DEADLINE 9 SUBMISSION – ANNEX 2

STONE HILL PARK LTD’S COMMENTS ON THE EXAMINING AUTHORITY’S SECOND DRAFT DCO

PINS APPLICATION REFERENCE: TR020002

Figure 12.6
Aircraft noise - daytime $L_{Aeq,16hr}$
contours - year of forecast maximum
capacity

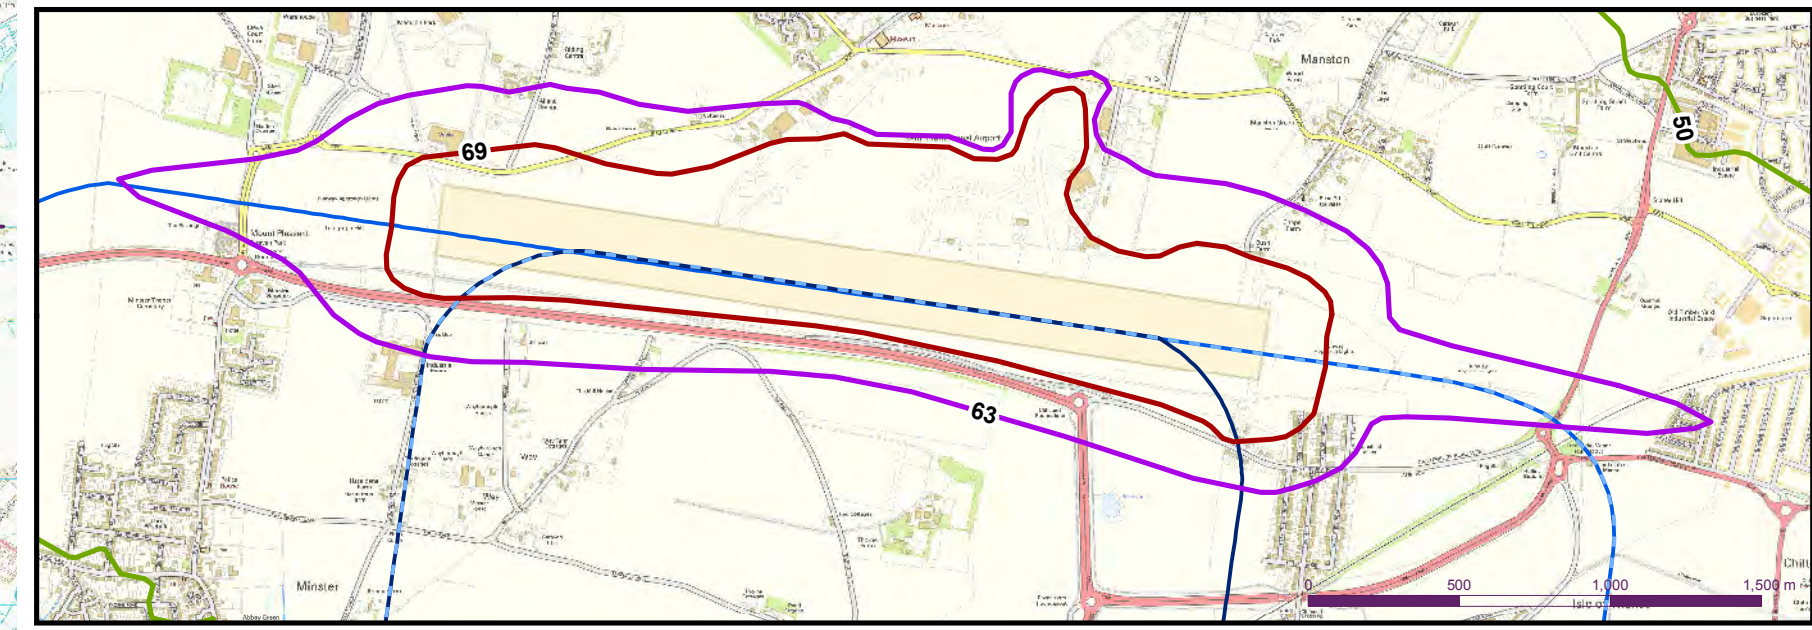
Schedule 2 – Requirement 9d.	<p data-bbox="824 946 2040 1042">SHP would note that placing area restrictions on the 50dB(A) Leq16hr (0700-2300) and 40dB(A) Leq8hr noise contours would not provide affective control of operations, particularly given the proximity of Ramsgate to the airport site.</p> <p data-bbox="824 1086 2040 1150">Accordingly, in order to provide adequate protection, noise contour caps should relate to higher ranges (e.g. 57dB(A) Leq16hr) with a consequential reduction in the area covered.</p> <p data-bbox="824 1190 2040 1327">The Applicant has consistently shown a complete lack of transparency regarding the noise impacts having not followed normal practice – the Applicant has not provided noise contours at 3 dB intervals, did not use the independent ERCD to prepare the noise contours and it has been extremely difficult for the local community to understand how, and by how much, they could be affected by aircraft</p>

Relevant Section of dDCO	SHP Comments
	<p>noise.</p> <p>It has therefore been left to interested parties such as Five10Twelve Ltd and NNF to submit reports prepared by the independent ERCD. These showed the noise contours at 3 dB intervals and highlighted material issues with the contours submitted by the Applicant.</p> <p>With regard to the robustness of the ERCD analysis, the ExA is referred to paragraph 9.175 of the Uttlesford DC planning committee report relating to the expansion of Stansted (included within the Appendix 3 referred to in the commentary on Requirement 9b. above), which states;</p> <p style="text-align: center;"><i>“For the purposes of the ES aircraft noise modelling has been produced by the CAA’s Environmental Research and Consultancy Department (ERCD), using their Aircraft Noise Contour (ANCON) model (current version 2.3). The ERCD is a specialist body within the CAA with national and international expertise on the assessment of aircraft noise. They produce noise contours for the designated London airports, and they generated the noise contours used by the Airports Commission. Their work is robust, authoritative and also impartial.”</i></p>
